Bramford – Twinstead:

Deadline 2 Response

Braintree District Council (20041141) &

Essex County Council (20041299)

TITLE: Figure 1  
 Accompanied Site Visit Inspection

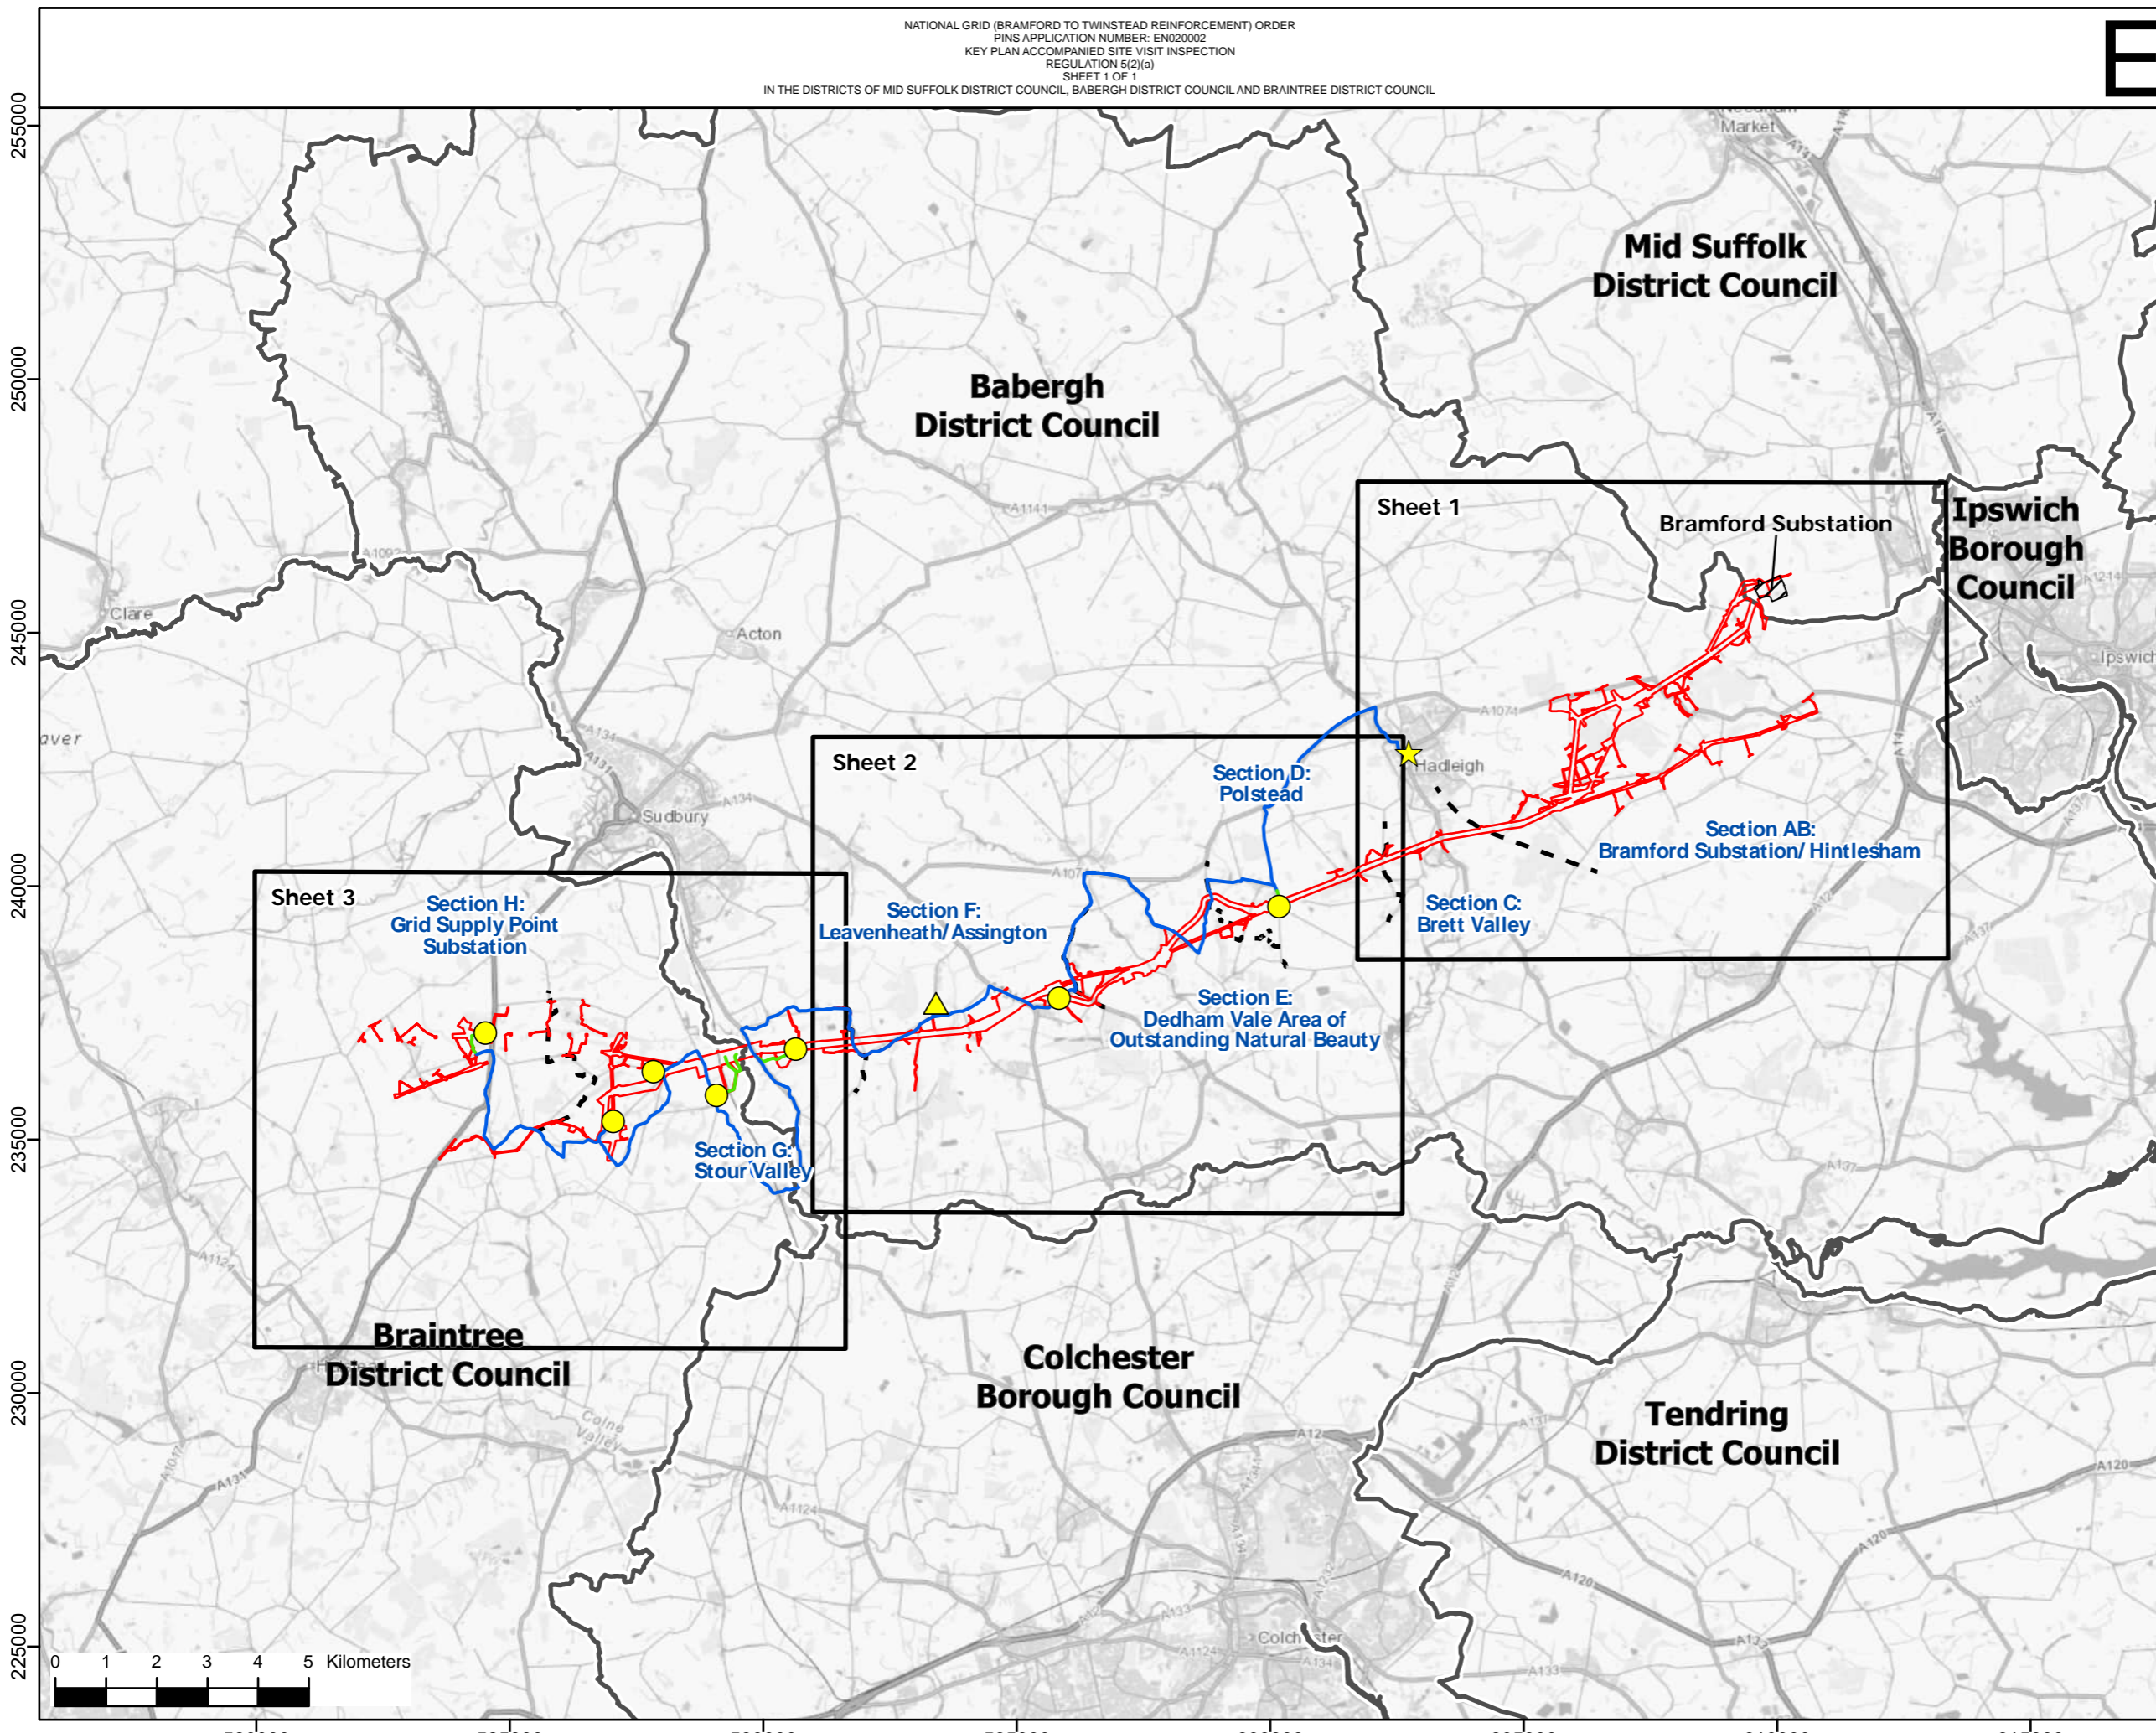
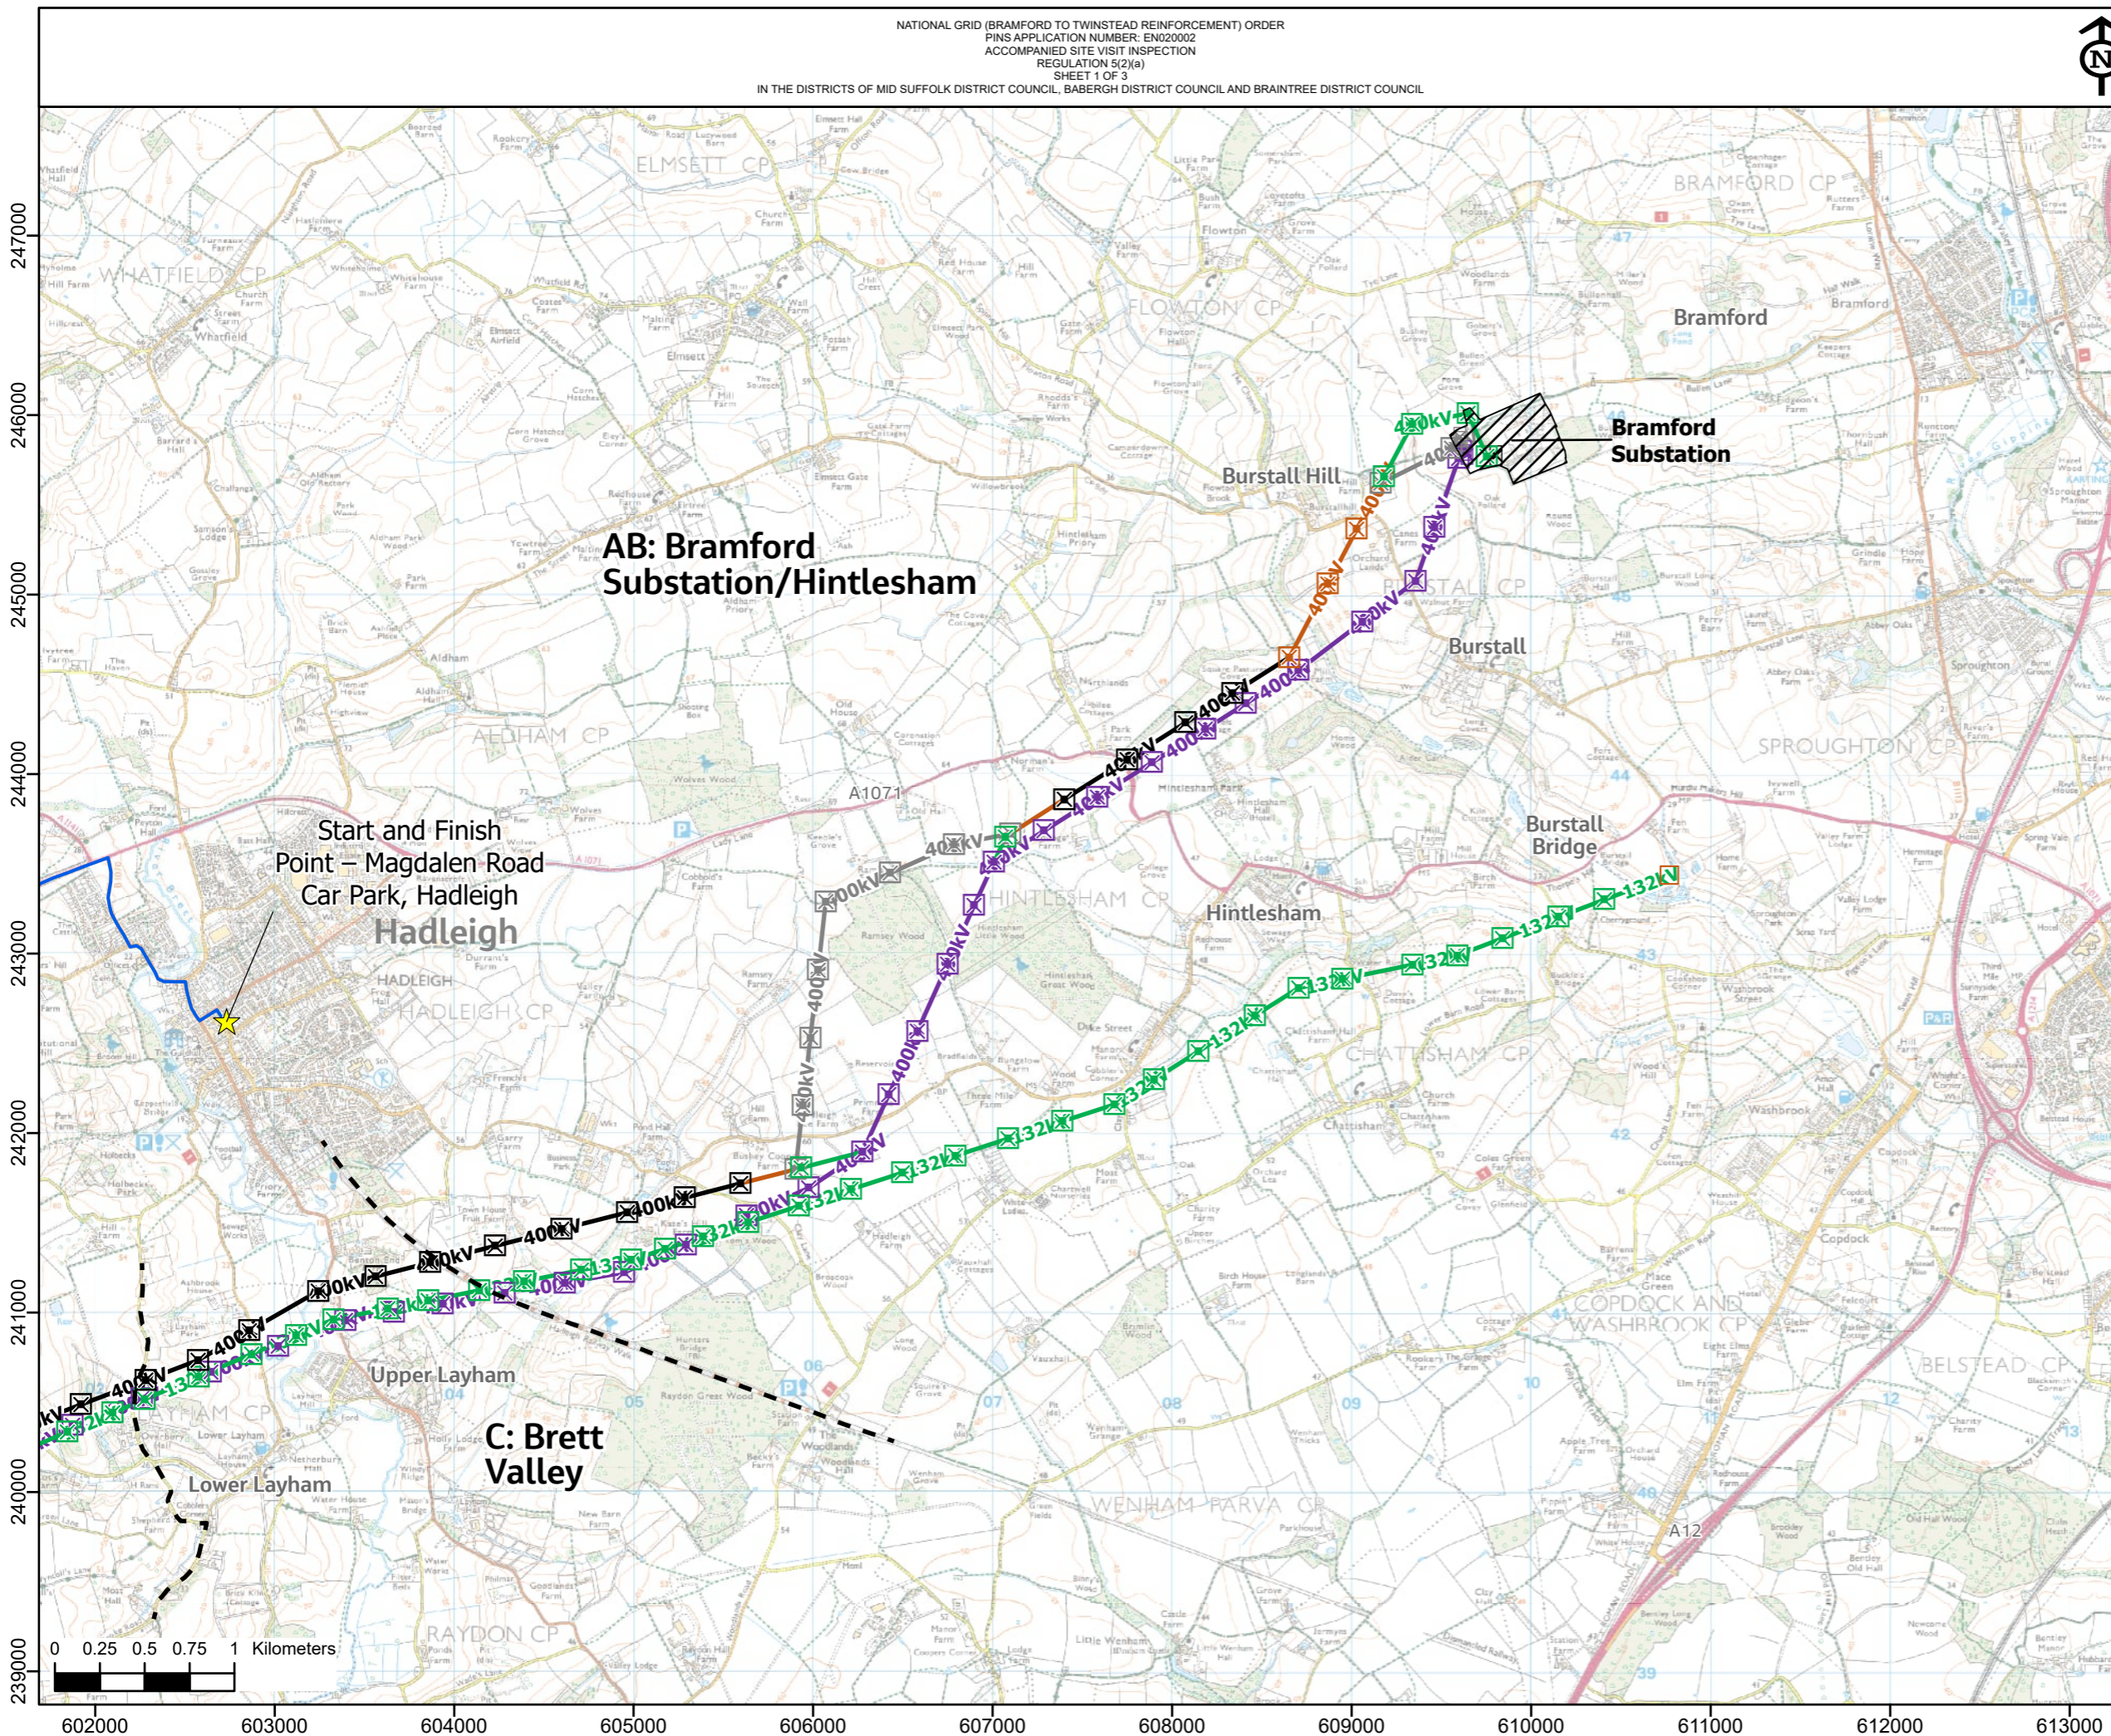
- 3.1.2 The Councils note that Essex is at the end of the route; now that nights are drawing in, it may leave insufficient time to see all of the site in daylight. As such, the Councils propose the ASI is split with those in Essex taking place the following day.

- 3.1.3 The Councils also note that the Draft Itinerary proposed by the Applicant has excluded most Public Rights of Way as locations due to these being publicly accessible and therefore deemed suitable for further unaccompanied site visits. If the proposed itinerary is followed as currently suggested, the Councils urge ExA to visit all the LVIA assessment viewpoints on the PRow network unaccompanied, as a minimum, in order to fully understand the potential long-term visual effects on recreational and other rural receptors and on the local landscape character.

- 3.2.1 There is no location point to view the proposed haul route from the A131 to the Stour Valley West Cable Sealing End Compound; Location 12 is the closest and that would not give an adequate view of the haul route location. The Councils therefore request that an additional Location Point is added to the itinerary to cover the proposed haul route near the entrance from the A131 as this would not be fully visible from any public right of way.
- 3.2.2 The Council's also ask that the ExA consider whether an additional location should be included to view the existing 132kV line which is to be retained

between the Twinstead Tee and the proposed GSP Substation. The purpose of this would be for the ExA to come to their own view about the landscape benefits of the 132kV line removal, as set out in The Council's Local Impact Reports, and which would be made redundant as a result of the proposals, and which the Council's see as being necessary.
